**LYNWOOD QUARRY
EXTRACTION AREA
MODIFICATION
(MOD 4)**

Response to Submissions

Prepared by
Umwelt (Australia) Pty Limited
on behalf of
Holcim (Australia) Pty Limited

Project Director: John Merrell
Project Manager: Brendan Rice
Report No. 3330/R19/V4
Date: February 2016

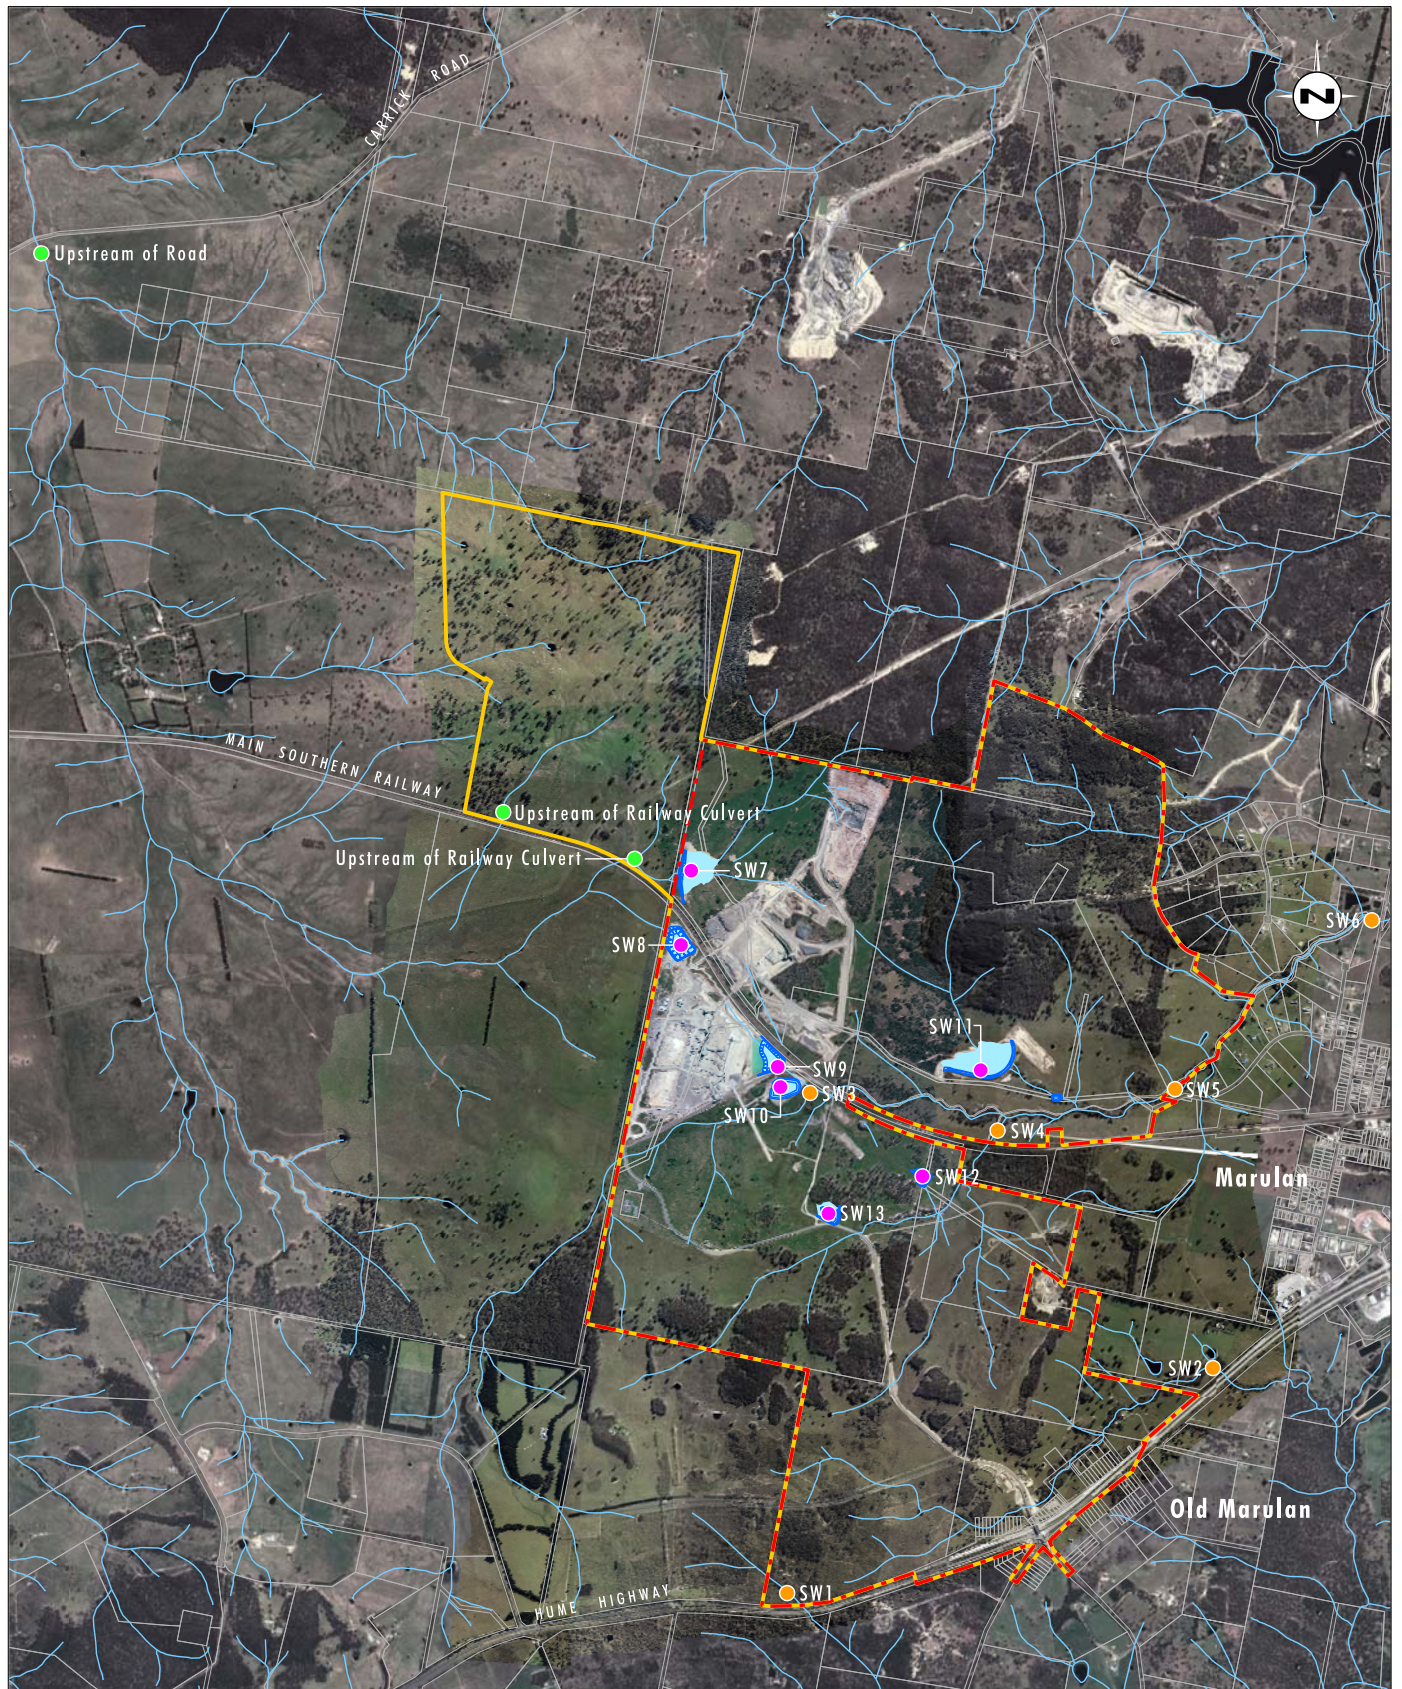
Adequate surface water and groundwater monitoring data should be collected on the granite resource site and the Lockyersleigh Creek catchment prior to commencement of the modification development. WaterNSW recommends there be an additional surface water monitoring site on the northern boundary of the western extension area noting that the watercourse is a third order stream at this location.

In regard to surface waters, three new surface water quality monitoring sites were proposed in the Surface Water Assessment within the Lockyersleigh Creek catchment area (refer to **Figure 2.2**). In response to the WaterNSW comment suggesting an additional water quality monitoring site on the northern boundary of the western extension area (i.e. on the third order watercourse), Holcim Australia agrees to include this location as an additional surface water quality monitoring site. The additional, i.e. 4th monitoring point, on Lockyersleigh Creek is also shown on **Figure 2.2**. The final details of the proposed surface water monitoring program will be contained within the updated Water Management Plan.

FIGURE 1
Location of Sediment Dams

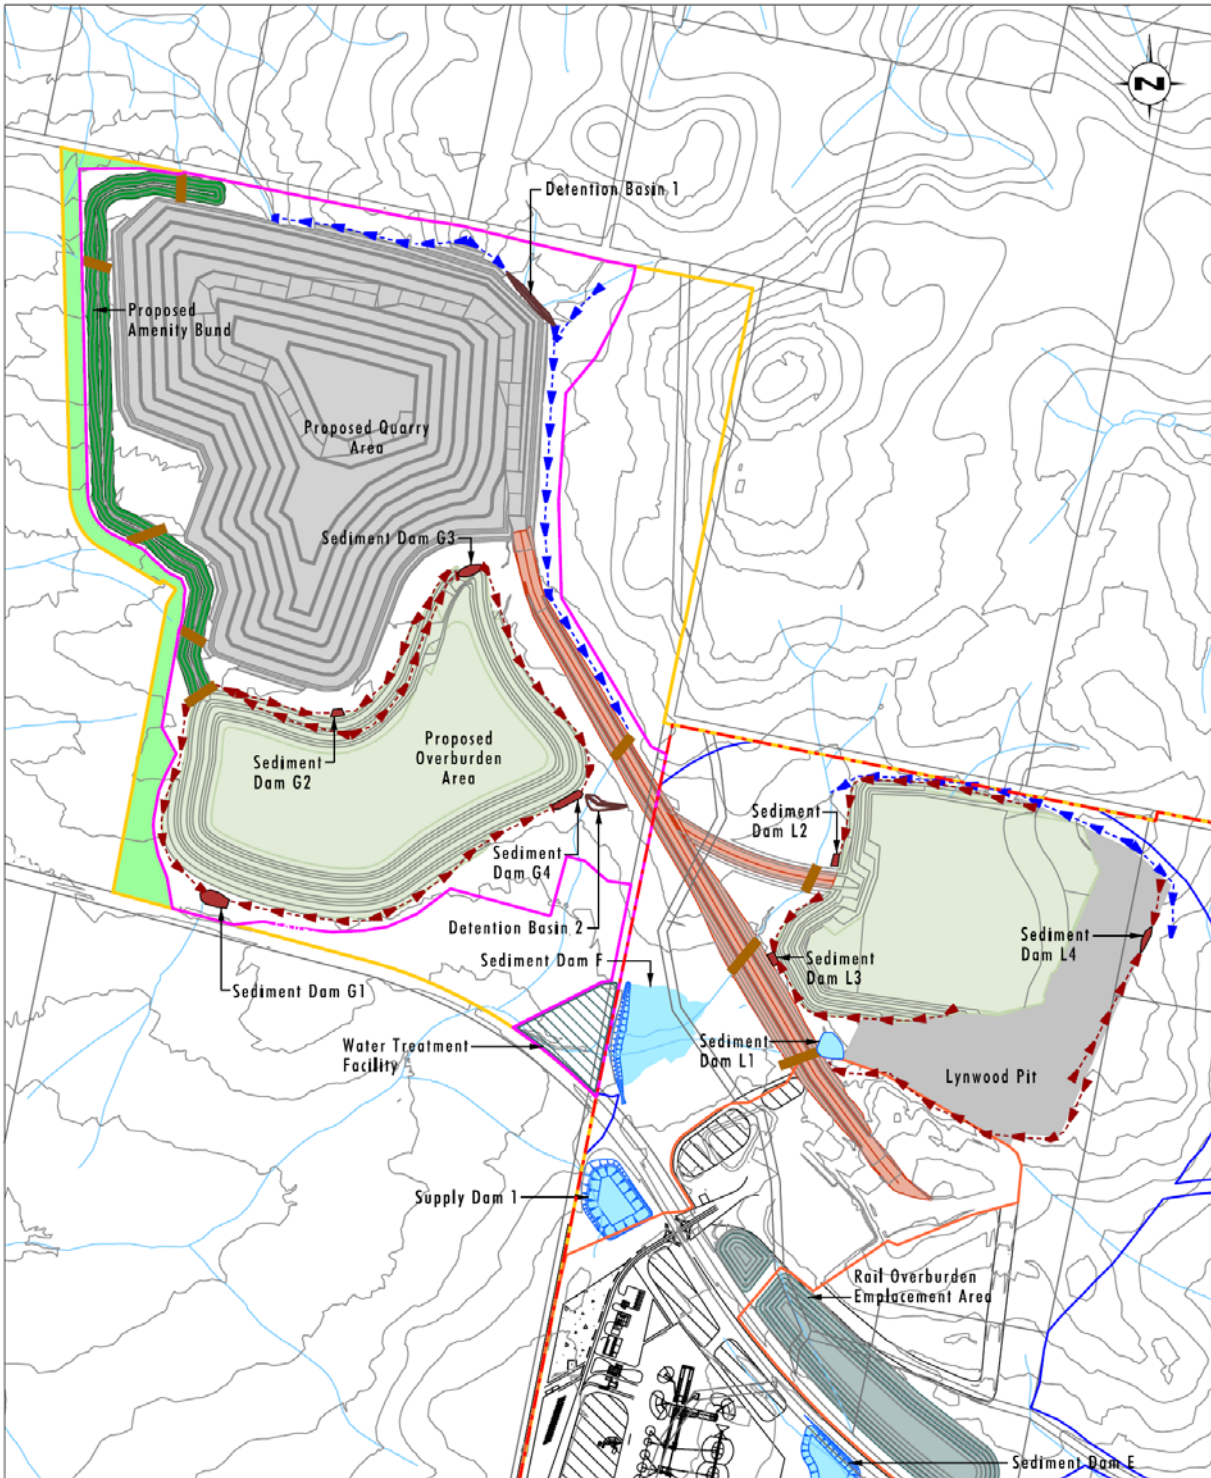
It is recommended that the 95th percentile 5-day rainfall depth of 40.8mm should be used in Sediment basin designed and be addressed as part of the updated Water Management Plan.

Holcim Australia acknowledges that the quarry site is located within the Sydney drinking water catchment and upstream of the Marulan town water off take on the Wollondilly River. Holcim Australia accepts Water NSW's recommendation that the new sediment dams related to the Modification Project (i.e. Dams G1, G2, G3, G4, L2, L3 and L4, refer to **Figure 2.1**) are constructed to manage the 95th percentile 5 day rainfall depth of 40.8 millimetres. The design capacities of the additional dams related to the Modification Project, taking into consideration the design rainfall depth change for the sediment dams are shown in **Table 2.1** and will be included to this design standard in the updated Water Management Plan.

It is noted that this design criteria will only apply to the new sediment dams proposed as part of the Modification Project, with the existing design criteria of the 90th percentile 5 day rainfall event remaining in place for the existing and approved dams at Lynwood Quarry.
